From: Beka Telles <btelles@ihdllc.com>
Sent: Friday, February 12, 2016 1:11 PM
To: Lindsey Ozbolt
Subject: Notice of Application - Yakima River Campground
Attachments: survey.pdf; 05-3000.pdf

Our office received the above referenced Notice of Application for Yakima River Campground, as the agent for the BNSF Railroad.

YAKIMA RIVER SHORT PLAT

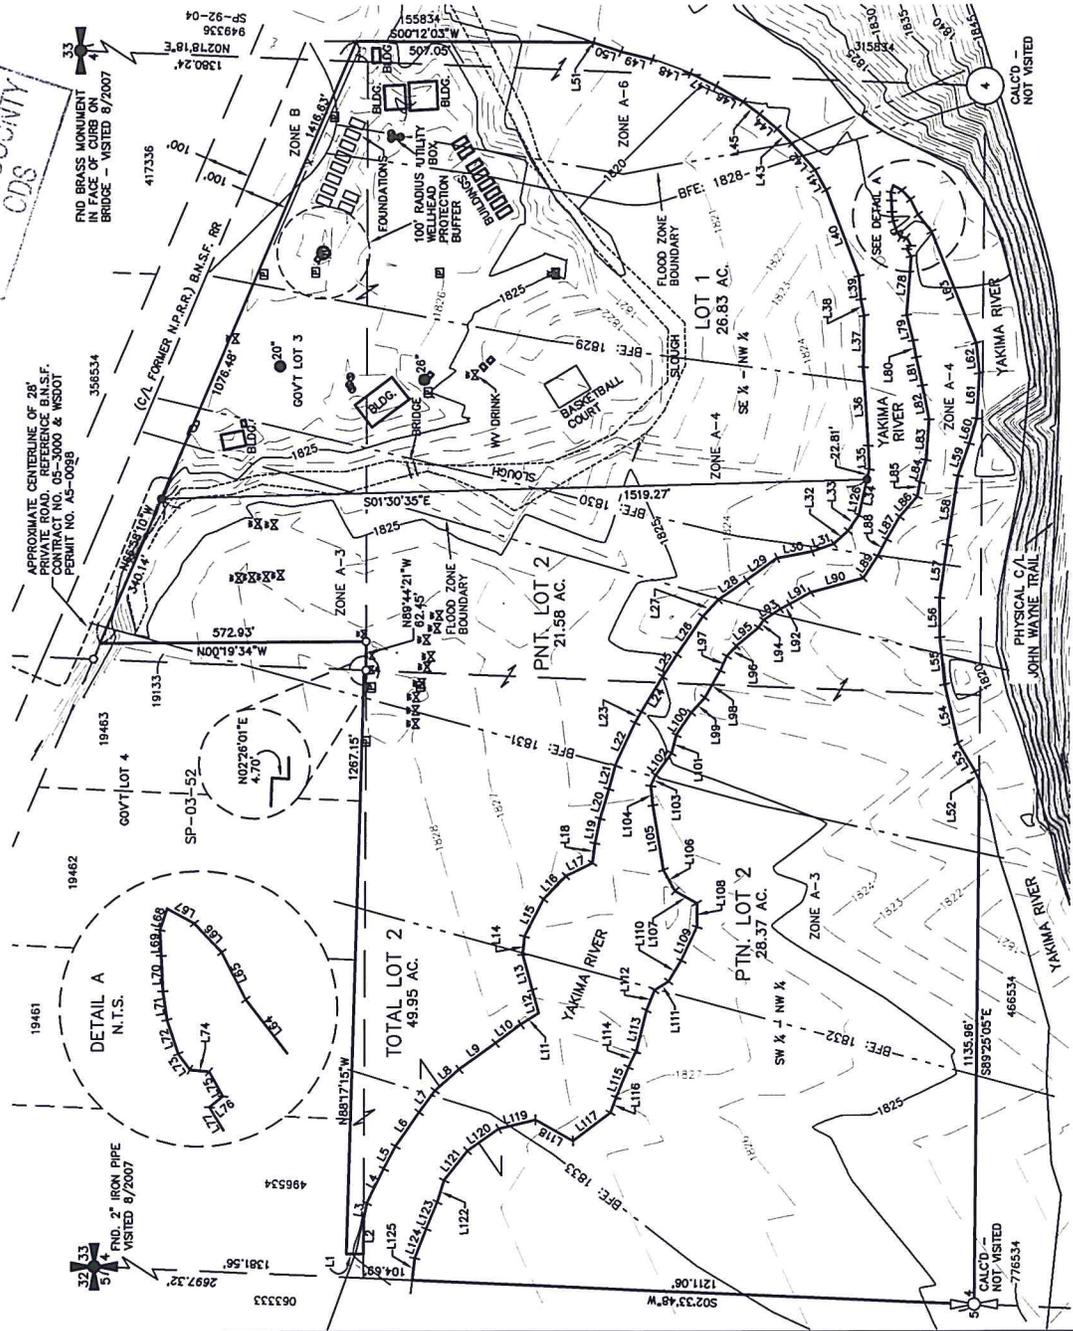
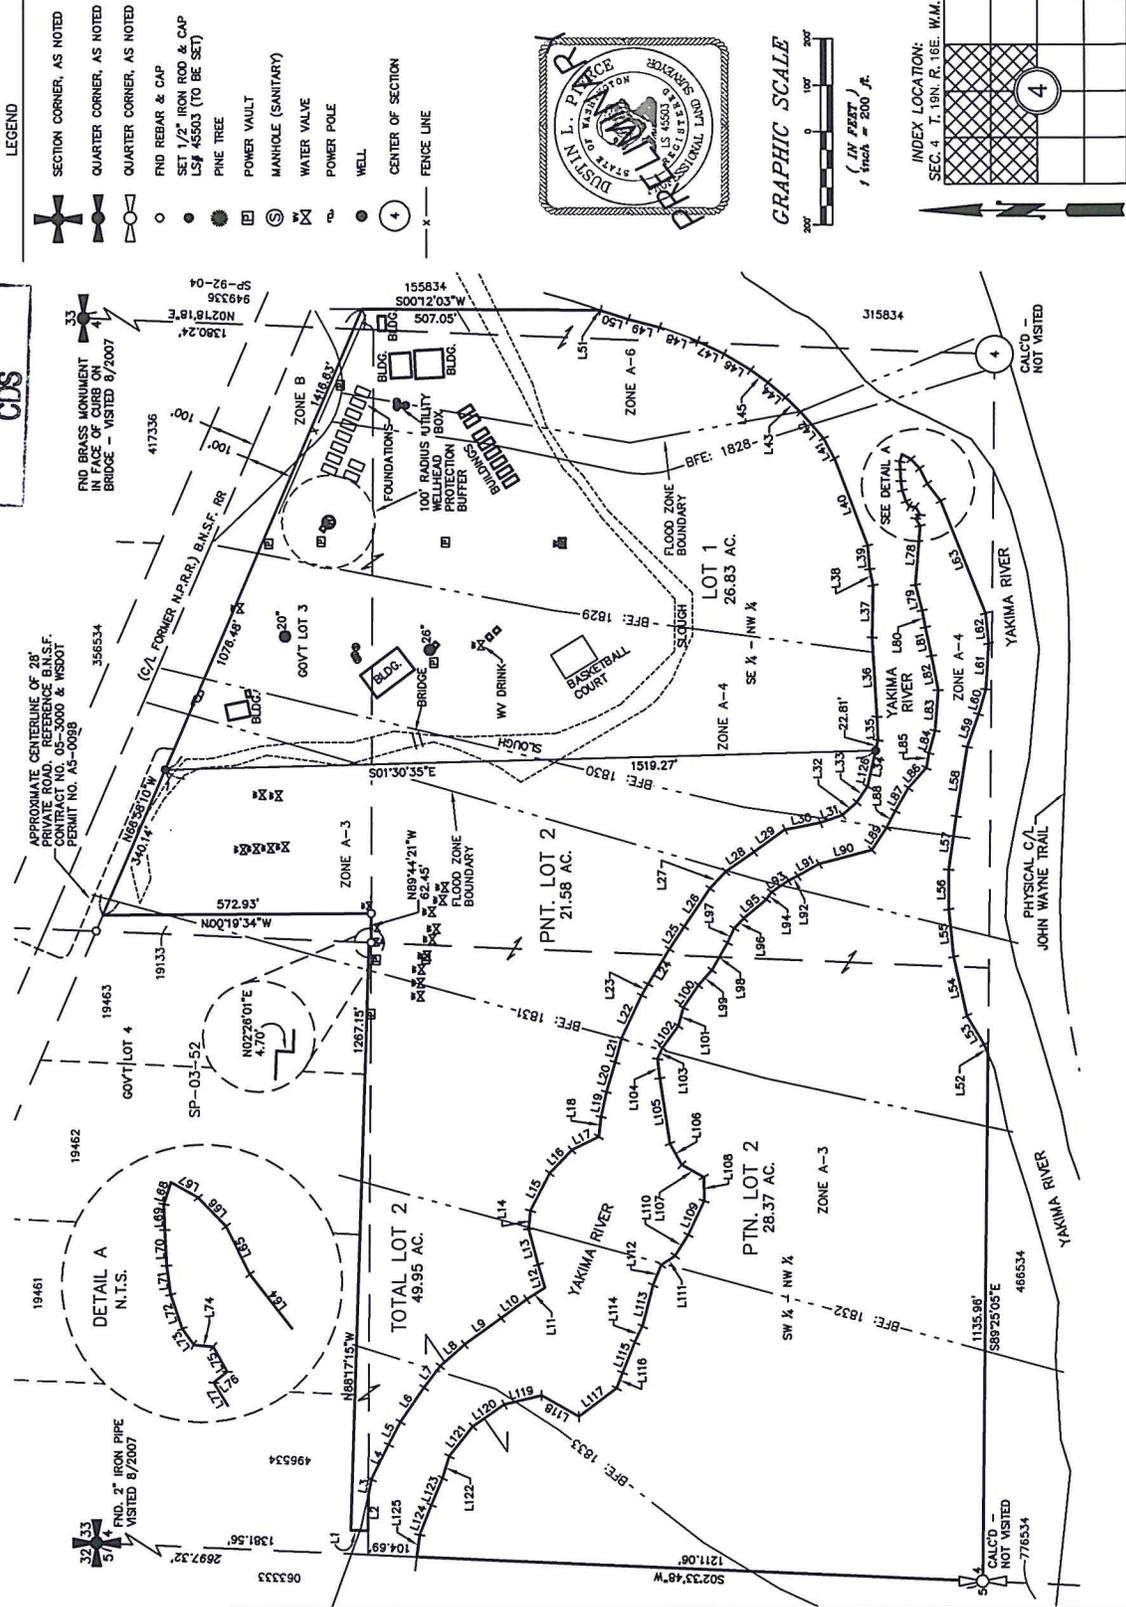
Looking at the survey done by Encompass (*attached to the Short Plat Application*), it references a BNSF Contract No. 05-3000, that Permit to cross the tracks only – the way I’m reading the survey it appears to show that the permit goes all the way to their property – which it does not, there is not currently legal roadway access to the property over the BNSF Right of Way. Additionally, that permit is for a Residential Private Crossing, so Teanaway Ridge, LLC would need to apply for a Commercial Private Crossing with the BNSF.
